From: [REDACTED]
Sent: 24 July 2026 13:40
To: Rhiannon Lloyd <Rhiannon.Lloyd@arun.gov.uk>
Subject: Re: [External] BR/102/26/A - 42 High Street

From: Rhiannon Lloyd <Rhiannon.Lloyd@arun.gov.uk>
Sent: Friday, 24 July 2026 13:09:10
To: Emma Robson [REDACTED]
Subject: [External] BR/102/26/A - 42 High Street

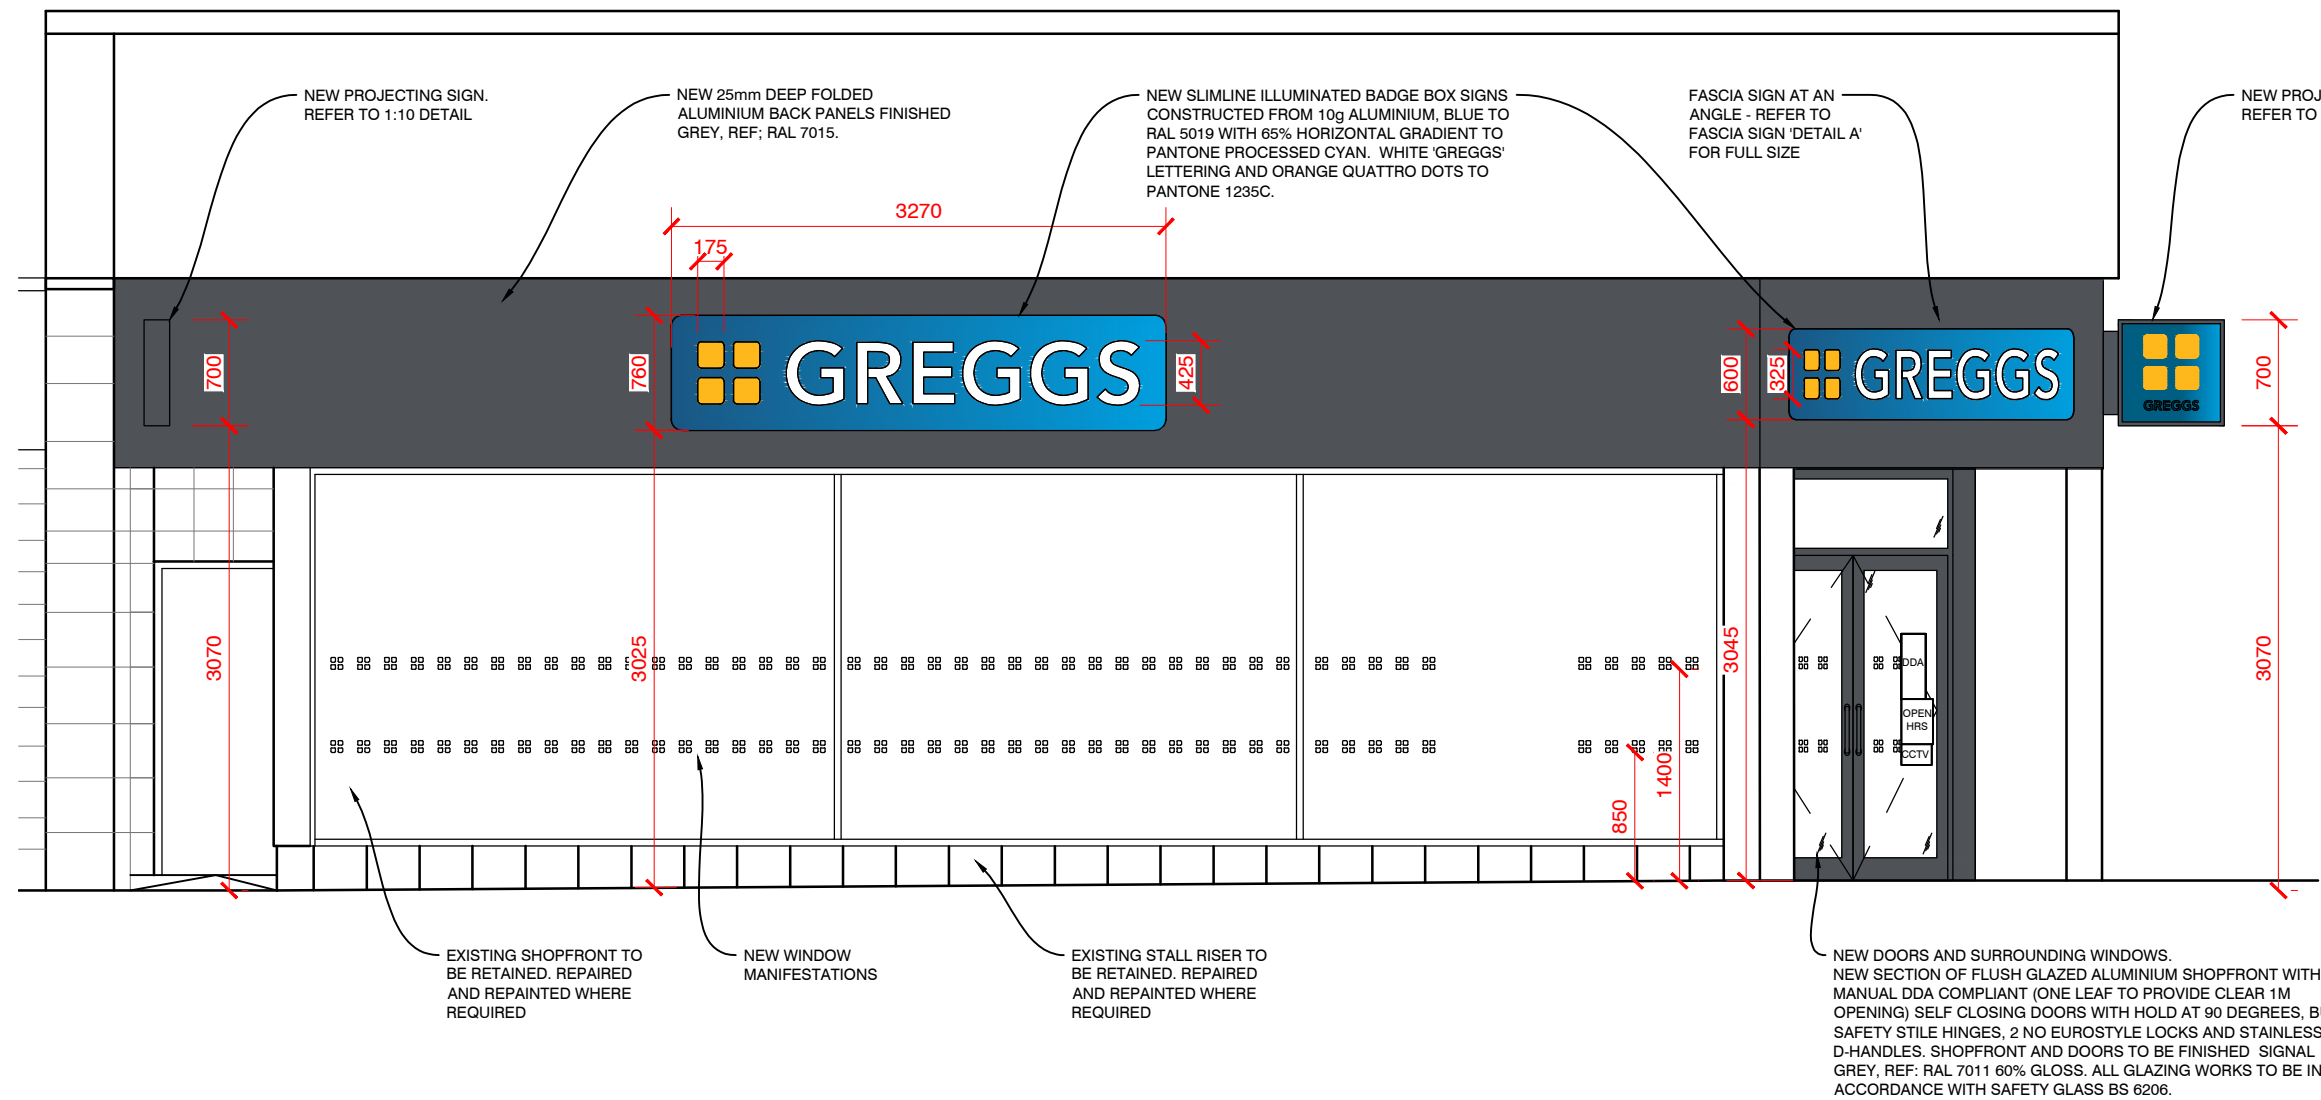
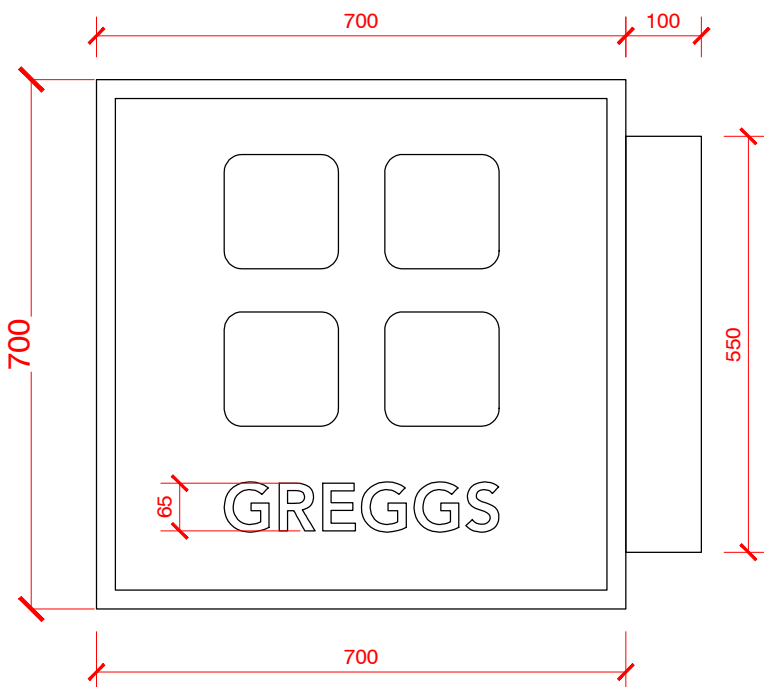
I note that your proposed illumination levels would not exceed 350cd/msq.
West Sussex standing advice states that illumination levels should not exceed 300cd/m in zone E4 (town centre) for adverts with an illuminated area 0 to <5msq during hours of darkness.

Please confirm you agree to reducing the level of illumination to a maximum of 300cd/msq during hours of darkness. This would likely be secured by condition.
I would appreciate your written confirmation by 5pm Monday 27th July.

Yes agreeable about change of luminance levels.
